PLANNING CONSULTATION RESPONSE

Application No	2025/0992
Proposal	Erection of a single storey extension to accommodate hydro pool and internal alterations to existing care home.
Address	Woodlands Lodge, 106 Hawshaw Lane, Hoyland, Barnsley, S74 0HH.
Date of Consultation Reply	24/02/2026
Consultee	Edward Jowett (Tree Officer)

PROPOSED SITE PLAN
SCALE 1:200

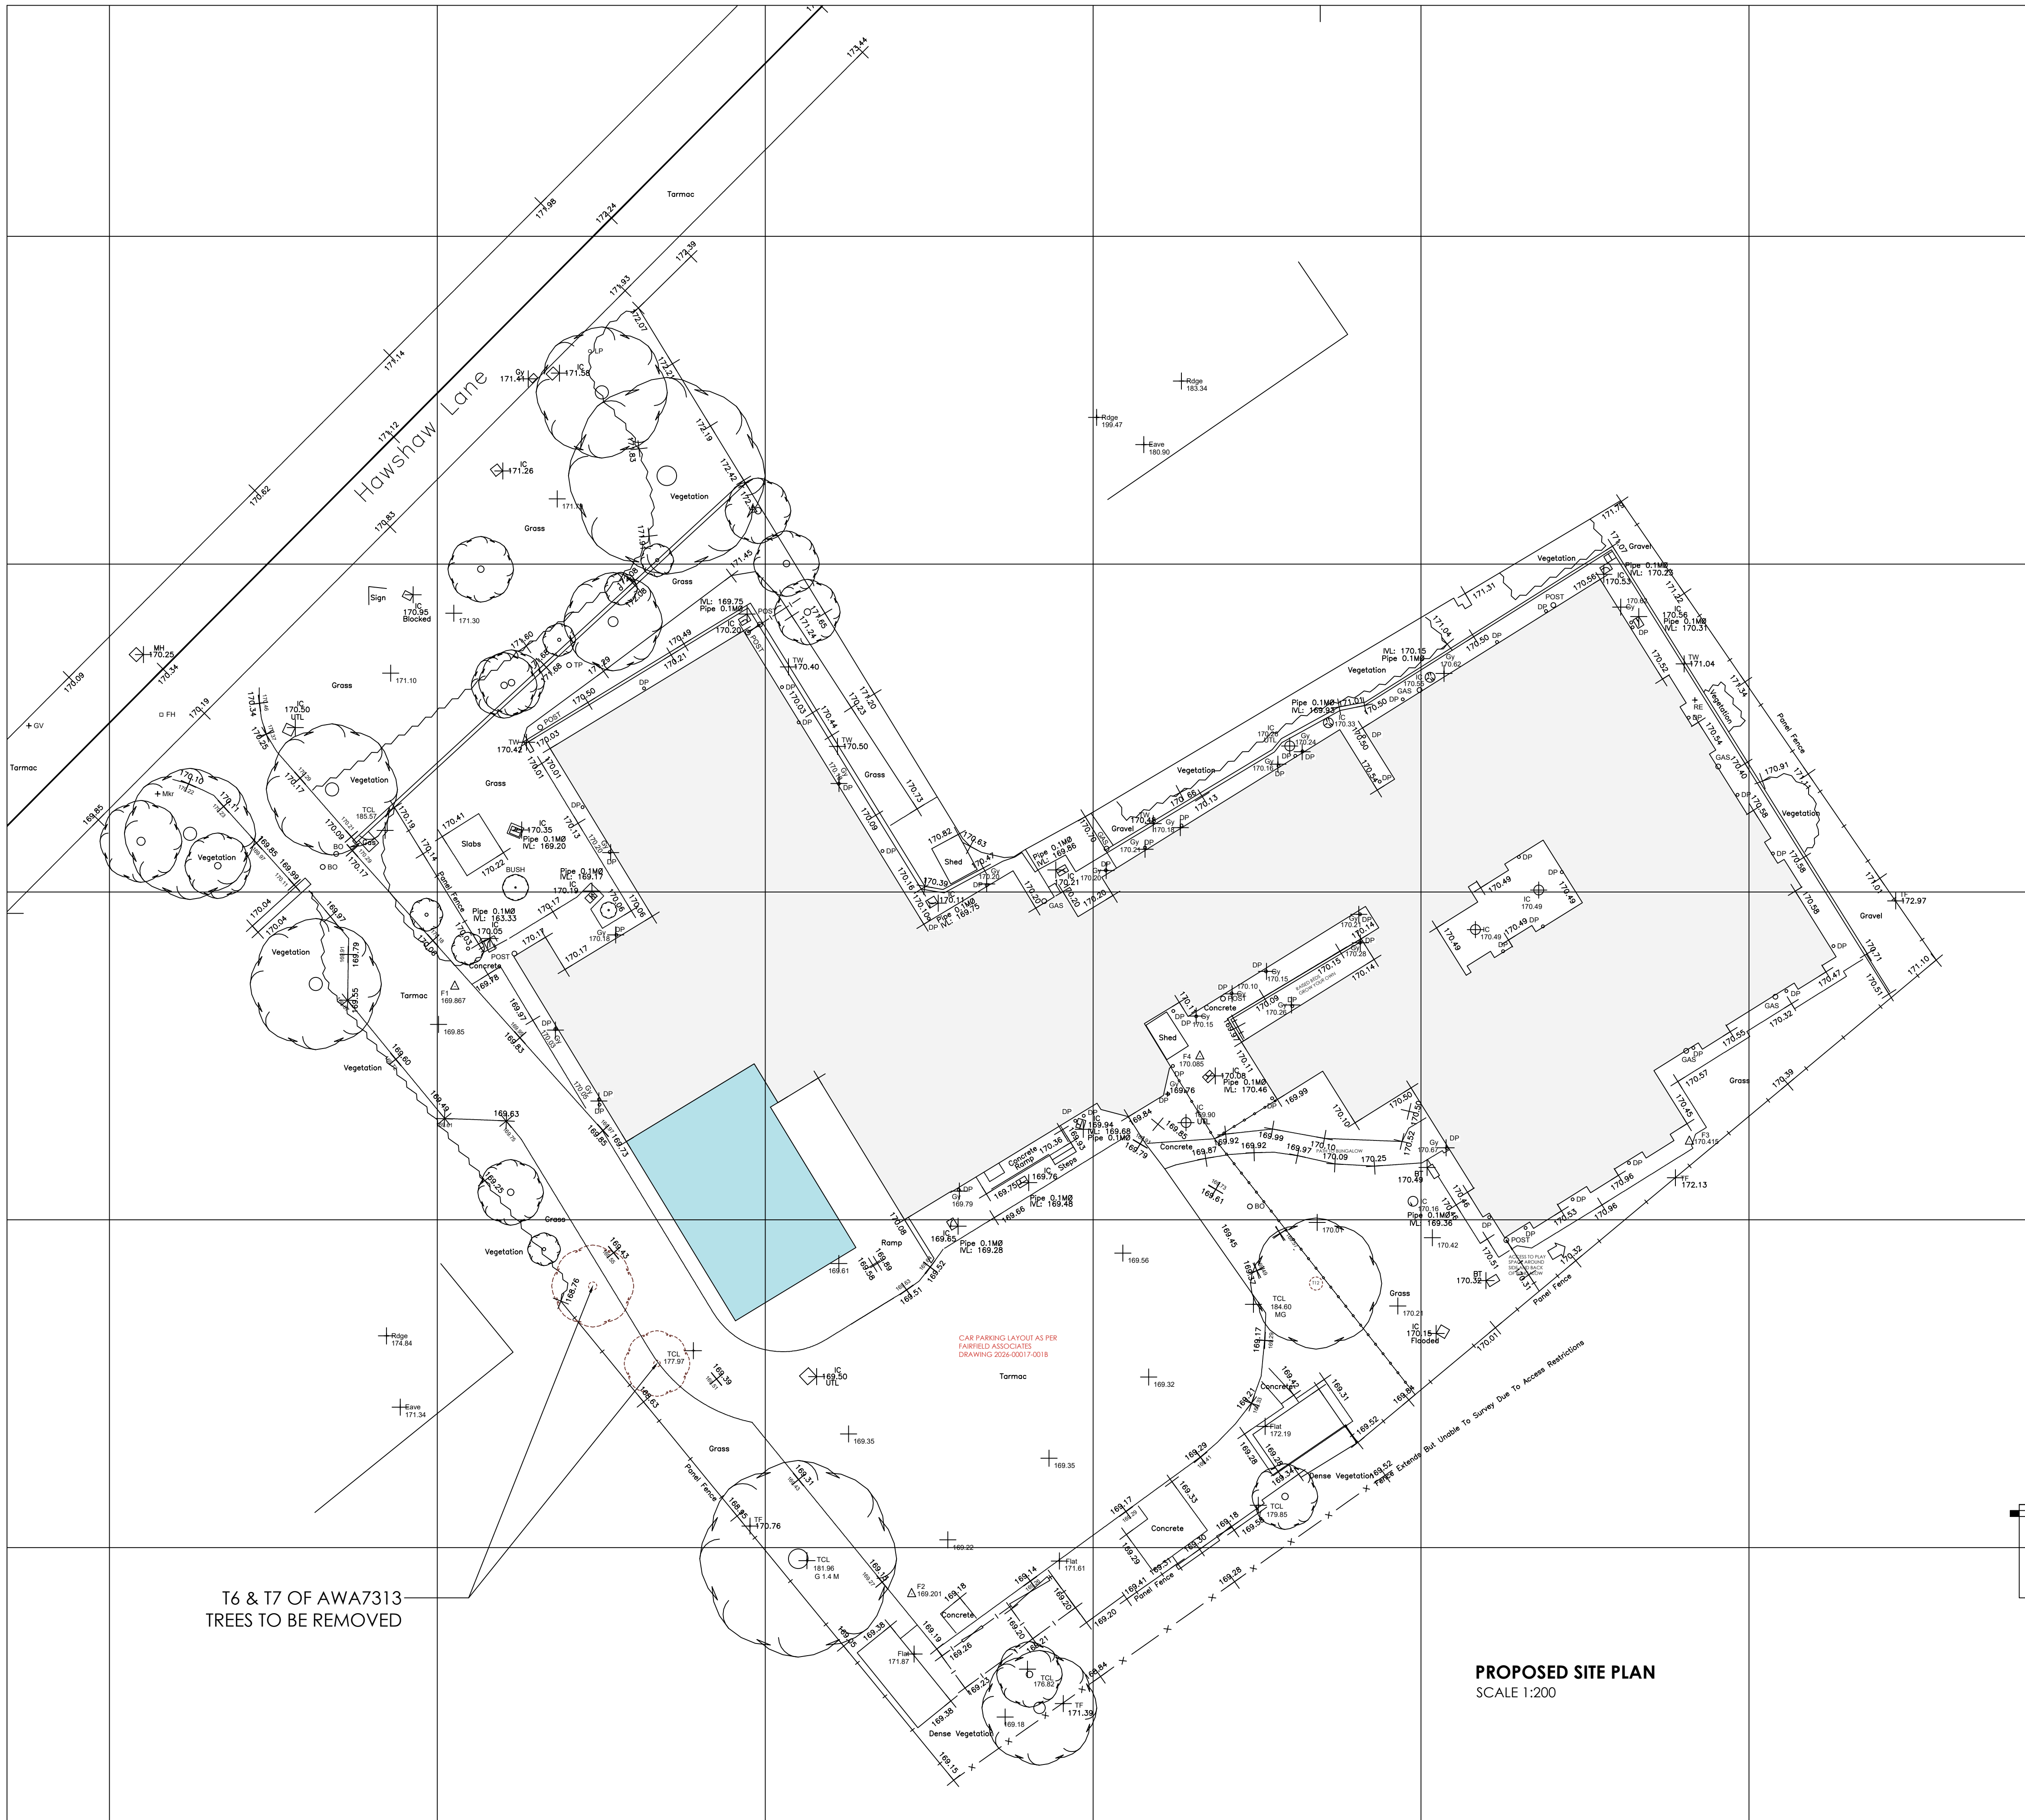
The arboricultural impact assessment does not appear to address the development works proposed and only notes impacts in relation to the interior alterations for the building and pays no reference to the proposed extension for the hydro pool and the changes to the alignment of the existing driveway which will impact upon T5, T6, T7 and T8 which are the key issues which need to be addressed. The issue appears to stem from the plans as the existing and proposed plans in the impact assessment both show the site as proposed with the extension and amendments to the driveway on both.

I would therefore ask that the AIA be updated to reflect the works proposed as part of this application so its appropriateness can be properly assessed.
